LAND AT GREVATT'S LANE, CLIMPING STAGE 1 RSA – DESIGNER'S RESPONSE

Stage 1 RSA – Designer's Response

Client/Project owner	Southern Co-operative Ltd
Project	Land at Grevatt's Lane, Climping
Type of document	Stage 1 RSA – Designer's Response
Date	26/04/2019
Reference number	BWREDE17

Drawn BW	Checked DM	Approved (DF)
Original dwg. size A3	Date of Issue Dec 2018	Scale 1:1000
Drawing Status PRELIMINARY	Drawing Number BWREDE-SK01	Rev. P2

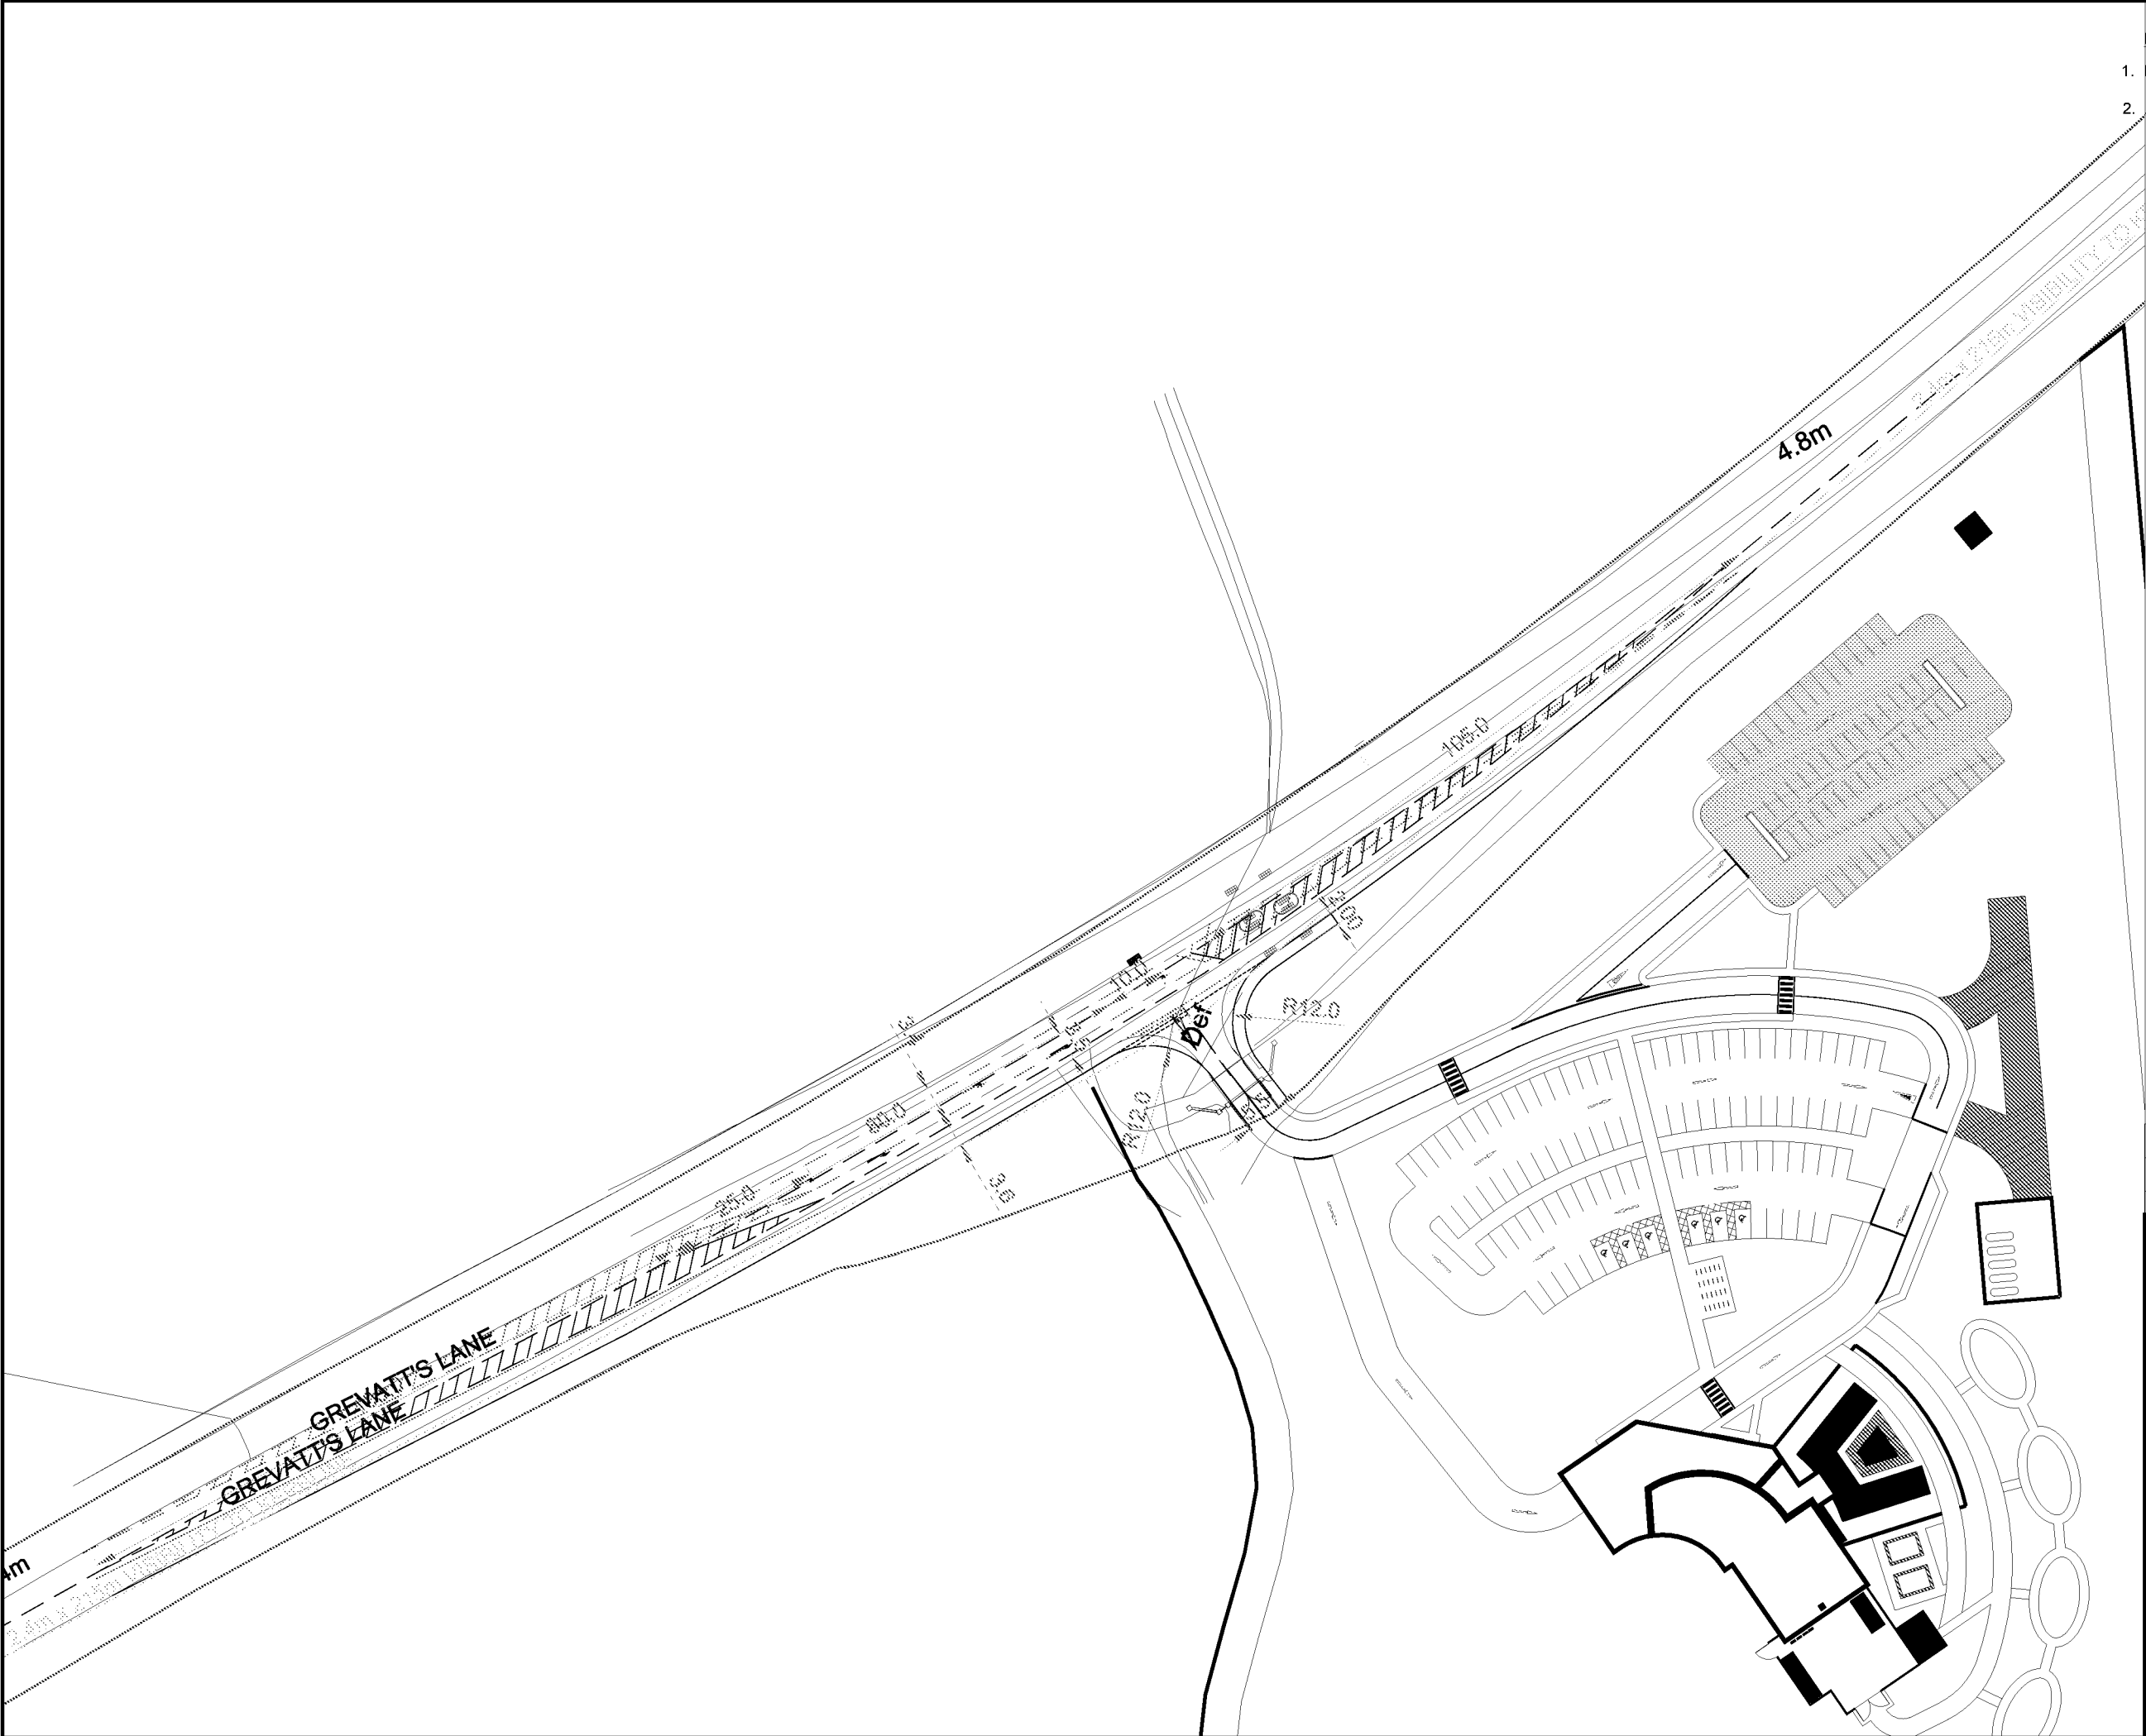
- 3.3.1 No forward visibility is shown on the drawings. Lack of sufficient forward visibility can lead to late-braking decisions, skidding, and loss-of-control type incidents including collisions with turning traffic.

- 3.4.2 It is recommended that the gates are set outside of the public highway and a suitable vehicle turning facility provided.

- 3.5.1 The oblique alignment of the proposed junction can create difficulties for some drivers, particularly the elderly, as this required them to look over their shoulder, when they may be suffering from restricted neck movement. There is a risk of damage-type collisions between egressing vehicles.

- 4.1.2 It is recommended that the refuge island is of sufficient width for dismounted cyclists to wait safely with their machines.

- 2.4.3 Should the site be closed upon entry, there is sufficient space within the proposed bellmouth access for a large car to turn and exit using a three-point turn.

- 2.7.1 In accordance with WSCC's Section 278/38 Highway Agreement Standard Details (drawing no. S278/38/19 Rev D), the proposed refuge island has been revised to measure 2.5m in width and 2.8m in length. This is demonstrated in the updated general arrangement drawing (drawing number BWREDE-SK01-P4) as contained in **Appendix E**.

Modified Large Refuse Vehicle (4 axle)
Overall Length 10.200m
Overall Width 2.500m
Overall Body Height 3.751m
Min Body Ground Clearance 0.304m
Track Width 2.500m
Lock to lock time 6.00s
Wall to Wall Turning Radius 11.330m

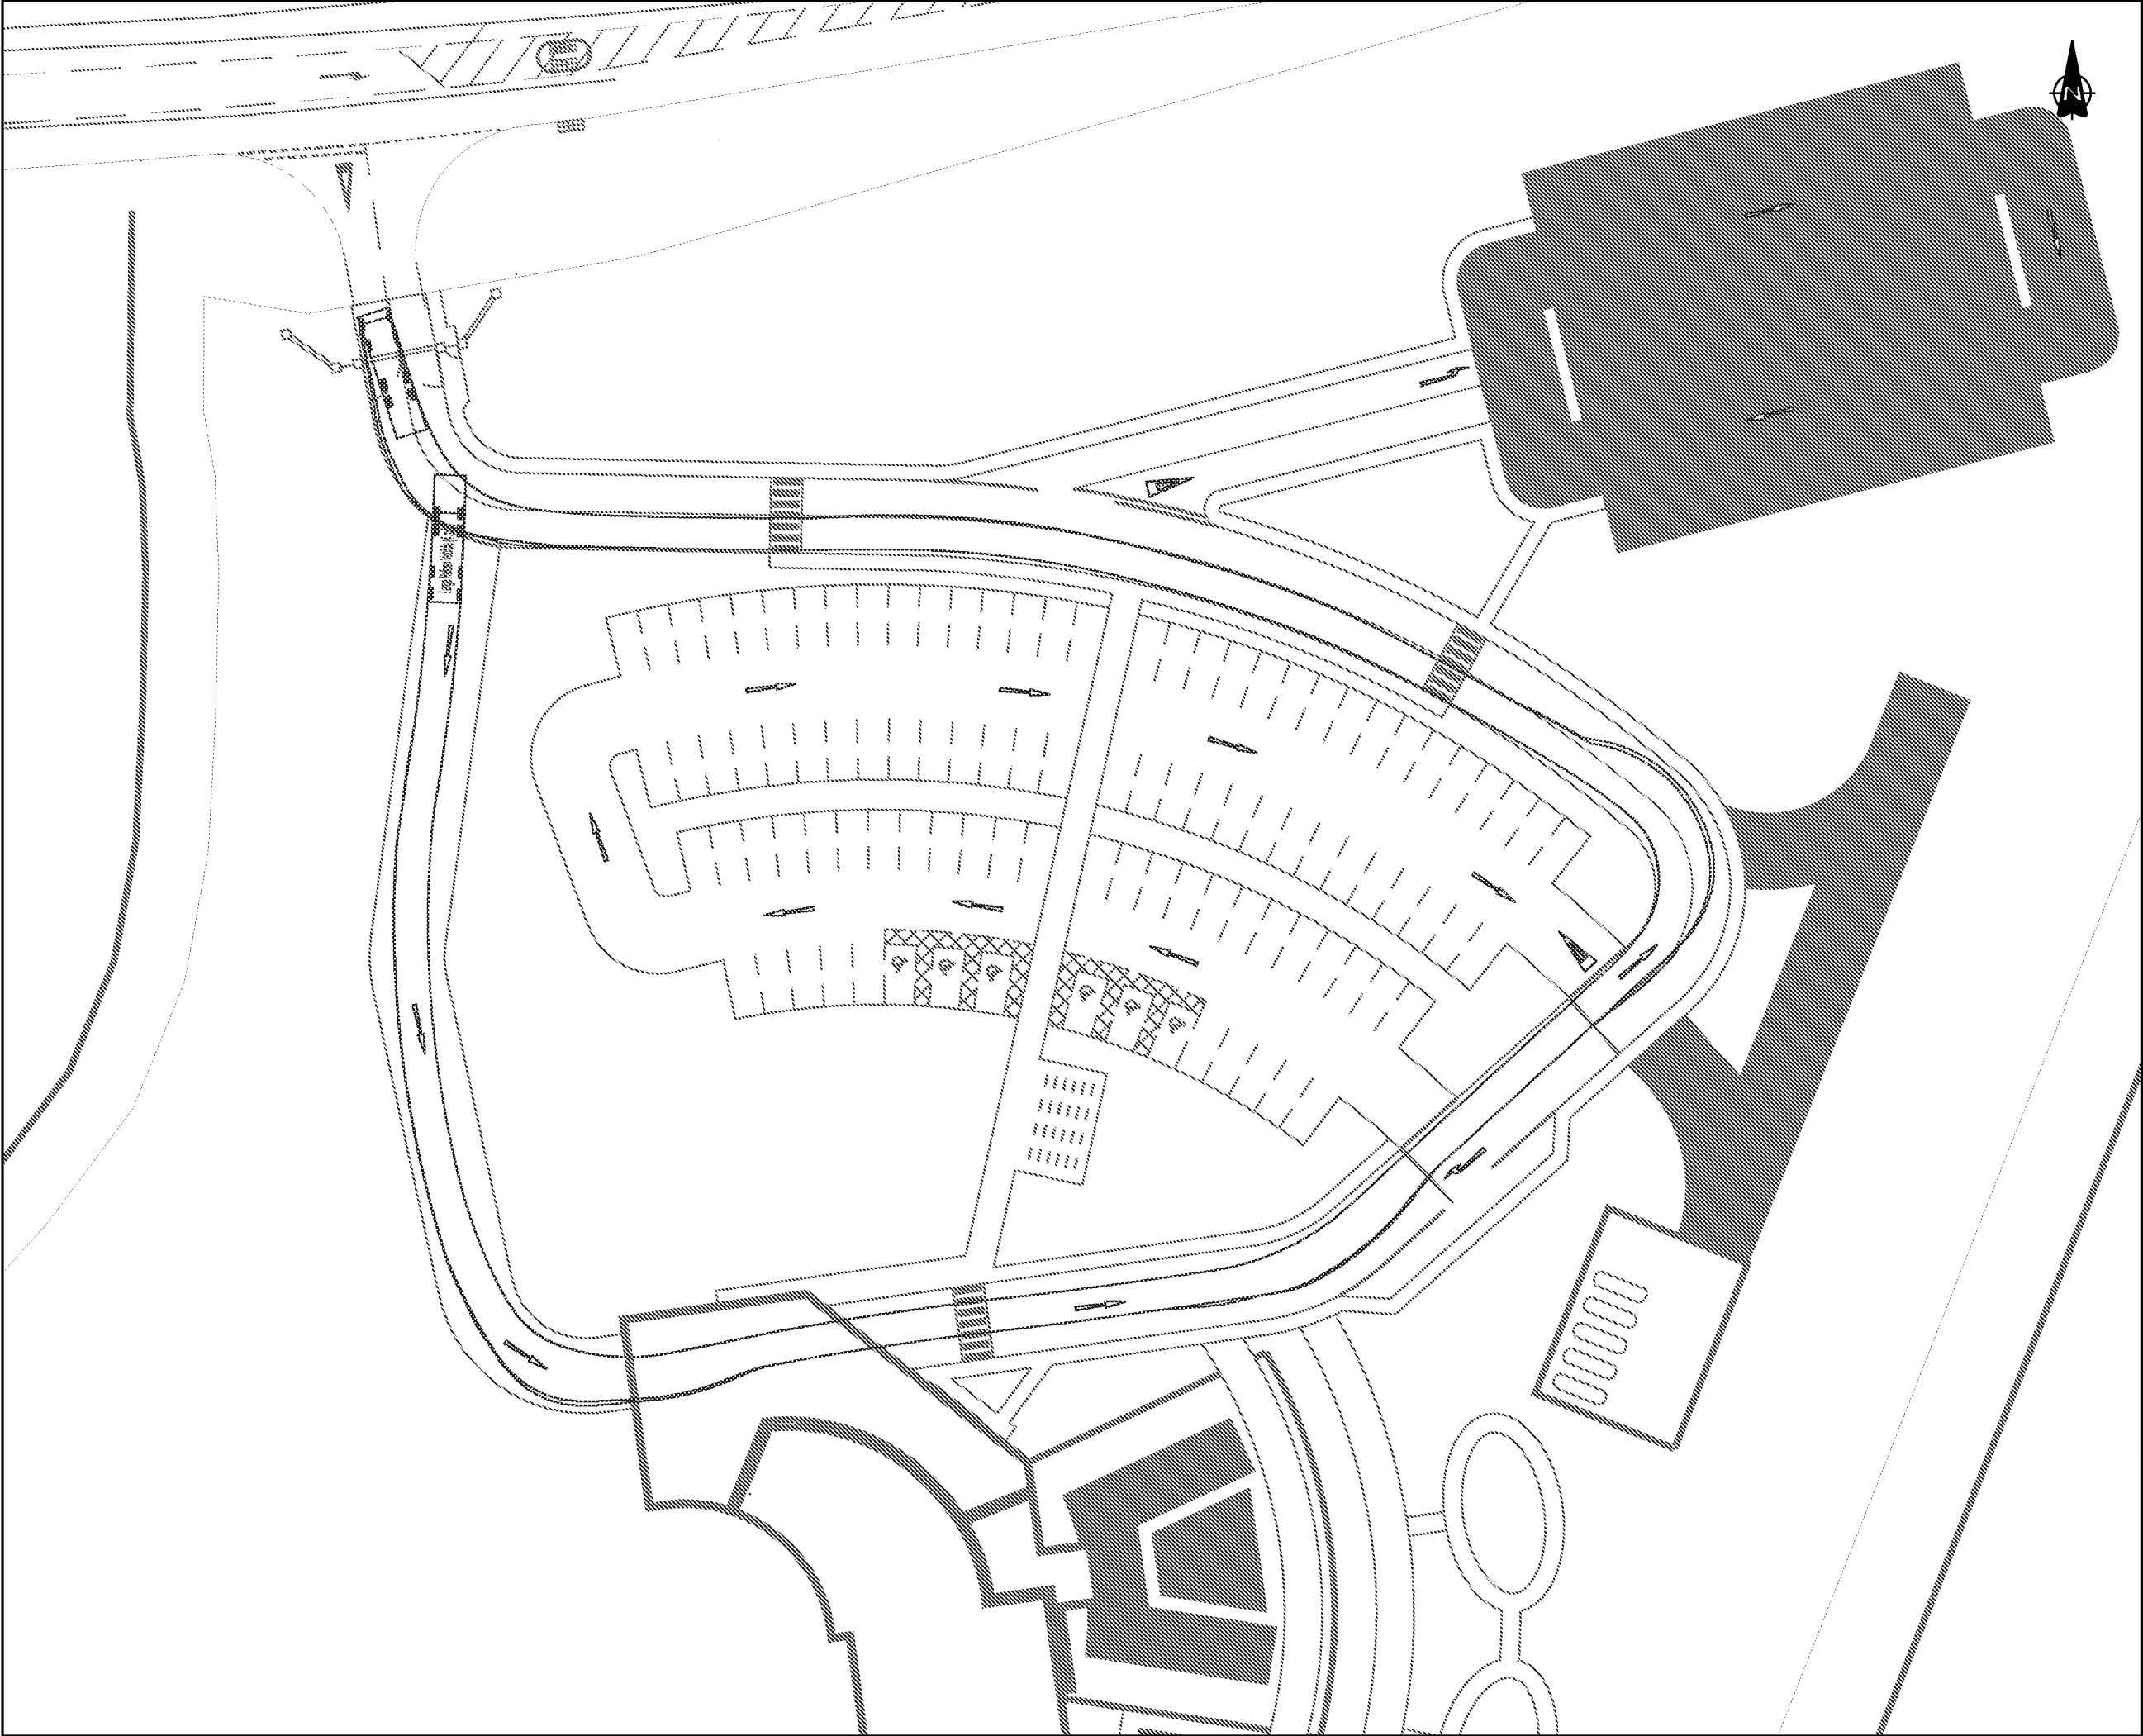
- 3.1.1 No swept path assessment is provided. The development may attract occasional large vehicles that without sufficient carriageway space may lead to damage-type collisions or collisions with users of the footway if the footway is overrun.

- 3.1.2 It is recommended that a swept path assessment be undertaken with for the largest typical vehicle anticipated to regularly and frequently visit the site to demonstrate safe and efficient access.

- 2.1.1 Swept-path assessment for a large refuse vehicle measuring 10.2m in length has been undertaken in accordance with Arun's refuse collection requirements, which is the largest typical vehicle anticipated to regularly and frequently visit the site. This drawing (BWREDE-SP4-P3) is included as **Appendix B**.
